**From:** Brian Banister [REDACTED]  
**Sent:** 18 February 2026 14:05  
**To:** Planning.Responses <Planning.Responses@arun.gov.uk>  
**Subject:** Arun Conservation Area Advisory Panel comments on applications

Hello,  
The **Arun Conservation Area Advisory Panel** wish the following comments to be taken into consideration in the determination of the following applications:

**LU/29/26/PL - 25 River Road, Littlehampton  
Objection**

DRAWING NUMBER  
2024.423.04

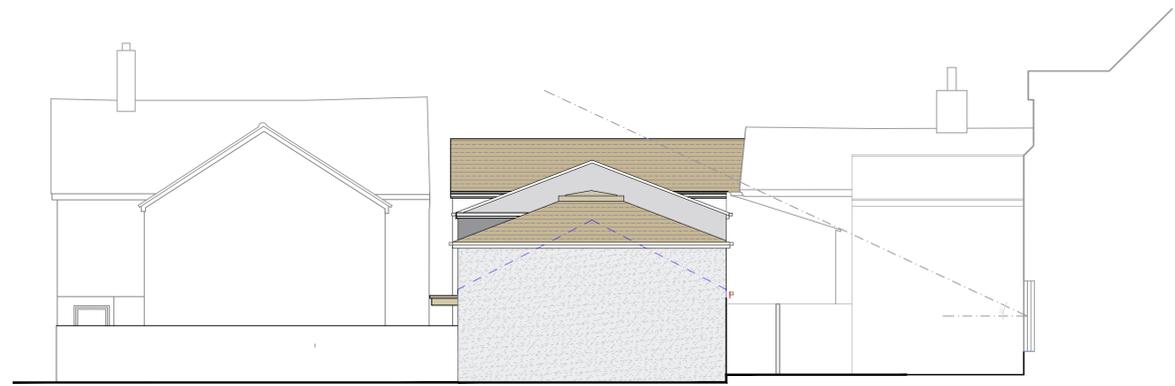
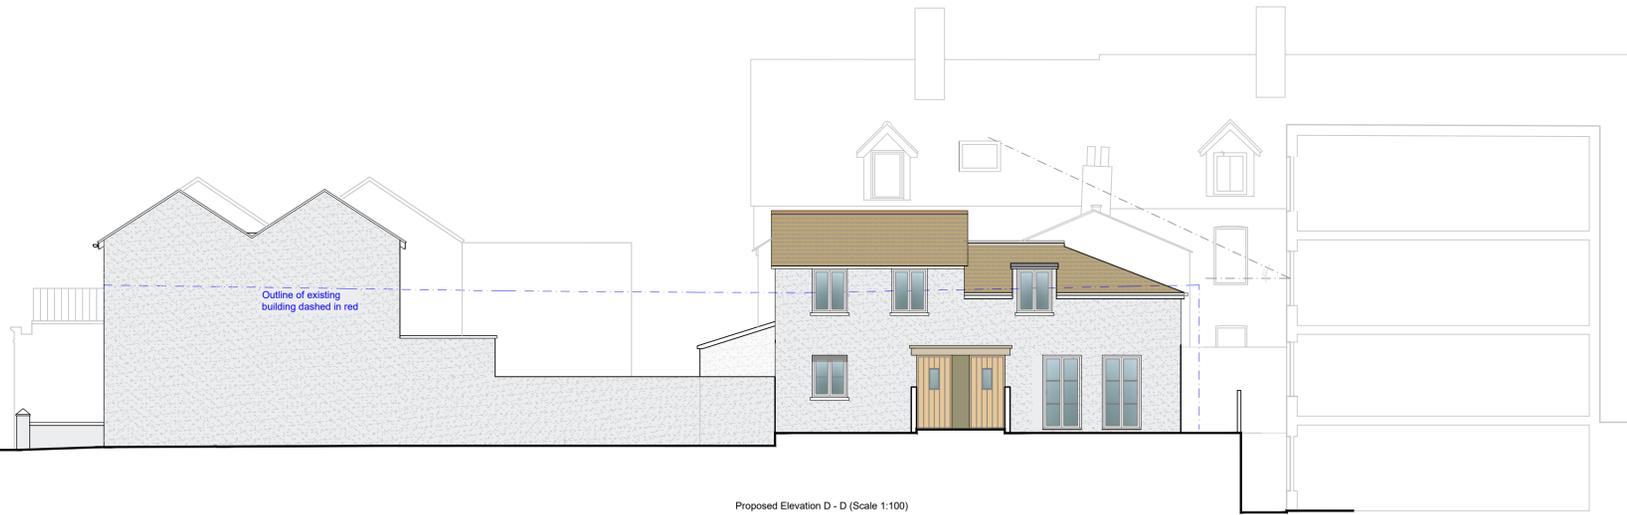
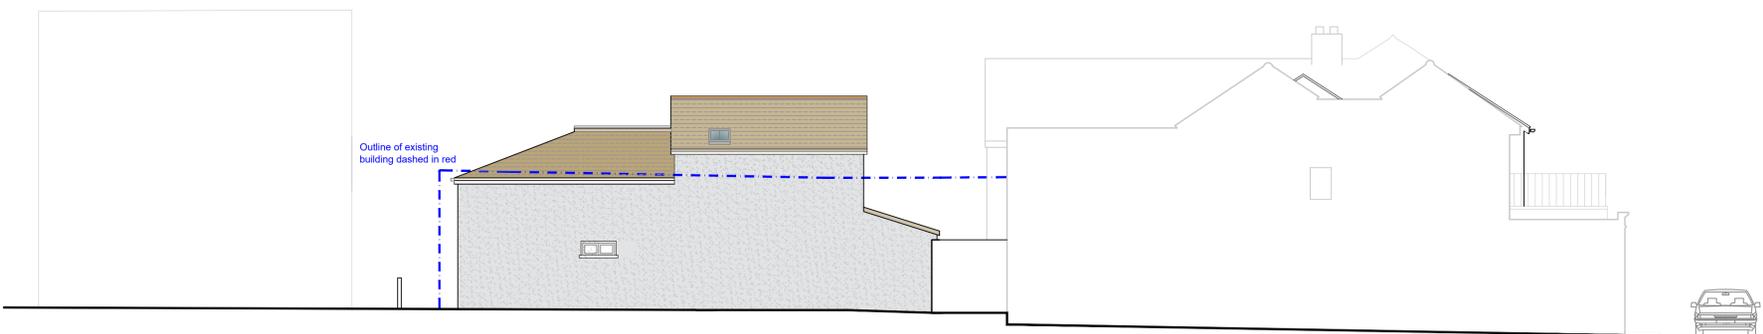
However, the Panel have severe reservations concerning the proposed roofing materials, and the detailing of the present scheme.

The traditional roofing materials in the conservation area are natural slate and plain clay tiles, with the former predominating in the late 19th Century/early 20th Century buildings. In many cases natural slate has been replaced with the ubiquitous Redland 49 concrete interlocking tile which is an inappropriate, bulky and detracting feature on traditional buildings with attendant adverse effects on the character and appearance of the conservation area. In addition, the colour of the tile fades over time, unlike natural slate and plain clay tiles which form an attractive patina as they age. In many improvement schemes in conservation areas the effort is made to replace interlocking concrete tiles with the natural slate originals.

Para 219 of the NPPF indicates that LPA's should take the opportunity in new development within conservation areas to better reveal their significance. This is relevant here where traditional natural slate is very much part of the heritage significance of this particular riverside conservation area. As such, the Panel object to the use of interlocking concrete tiles proposed on both of the new buildings and natural slate should be insisted upon. An inspection of the terrace on the River Road frontage will show that the westernmost property still retains its natural slate roof, and that should be the exemplar, not the inappropriate roofing materials on the remainder of the terrace.

The Panel welcome the proposed continuous domestic frontage proposed for the new River Road properties, rather than the disruption with a vehicular opening which was a feature of previous schemes. In addition, it welcomes the attempt to imitate some of the features on nearby traditional elevations such as the pattern of window openings. The Panel would suggest, though, that the fenestration and doorways need to be deeply recessed in the external walling, in order to reflect that on nearby buildings. The doorways would benefit with a simple hood, again to emulate those nearby. The fenestration is described as white timber in the application form, which is welcomed and appropriate but it should be established that the windows will be vertically sliding sashes.

On the Terminus Place frontage, the scheme would benefit with a break in wall plane where the roof changes height.
